From: Michael Eastham <Michael.Eastham@arun.gov.uk>
Sent: 10 September 2020 13:42
To: Planning.Responses <Planning.Responses@arun.gov.uk>
Subject: FW: A/109/20/RES - Land South of Water Lane, Angmering.

Please upload onto Ocella the attachments and the email below which is a further representation from **Angmering Parish Council** to reserved matters application **A/109/20/RES** relating to Land South of Water Lane, Angmering.

Angmering Parish Council would like to further enhance their objection of this application and use references to our Neighbourhood Plan as well as Arun District Councils design guide.

5.6 Land Use, Amount and Density

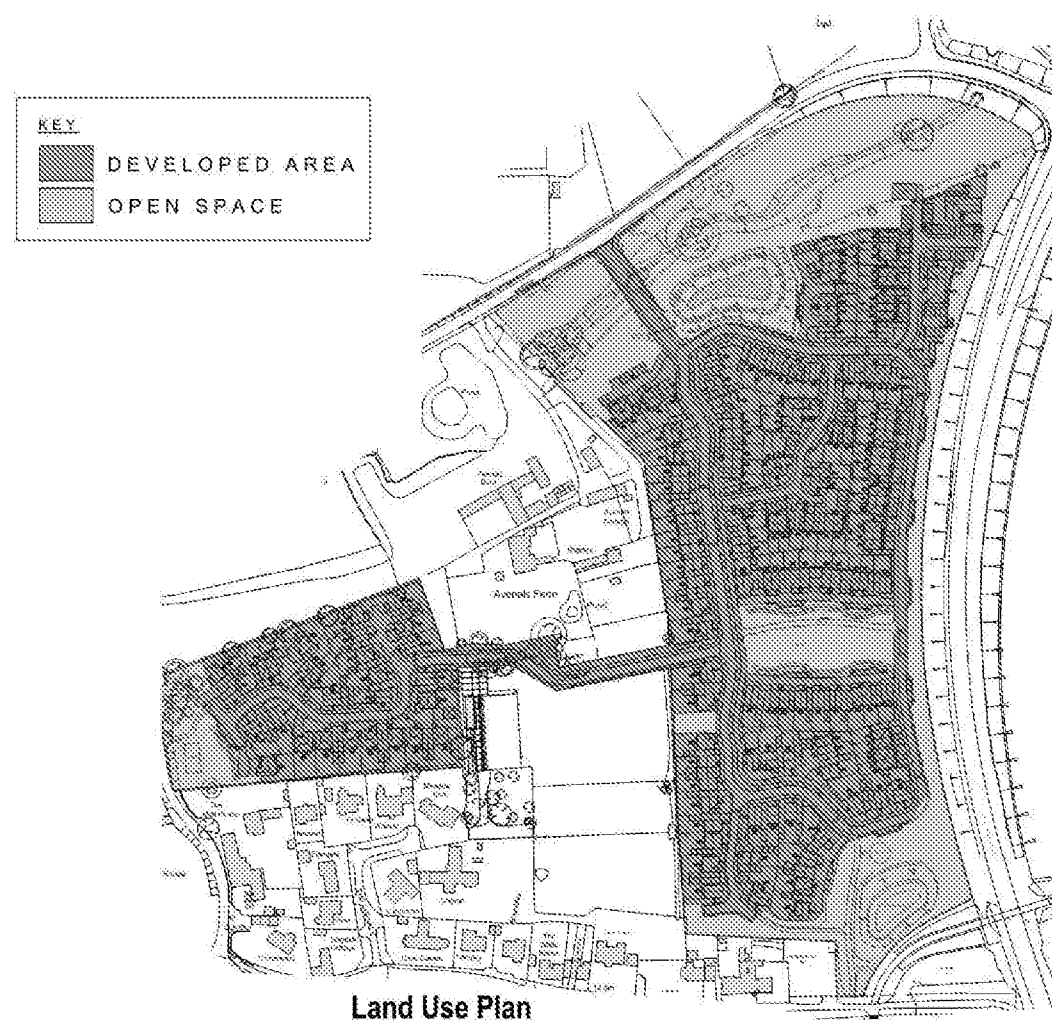
The below screen shot of the application document “Design and Access Statement” section entitled “Land Use, Amount and Density” states this development would be “below 35 dph” As you can clearly see from the attached density survey – very little of Angmering is anywhere near that density – let alone the areas directly adjacent to the proposed development.

The development proposal is for 175 dwellings in total, in accordance with the Outline approval. The scheme proposes a low density of development, averaging below 35 dph across the site based on the net developable area. The development is of a loose character with significant areas of open spaces incorporated throughout the development. A mixture of built form containing a small apartment block, small terraces, semi-detached and detached dwellings providing a range of dwelling types and sizes. Generally dwellings will have generous rear gardens and reasonable front gardens to ensure a landscaped frontage to the built form.
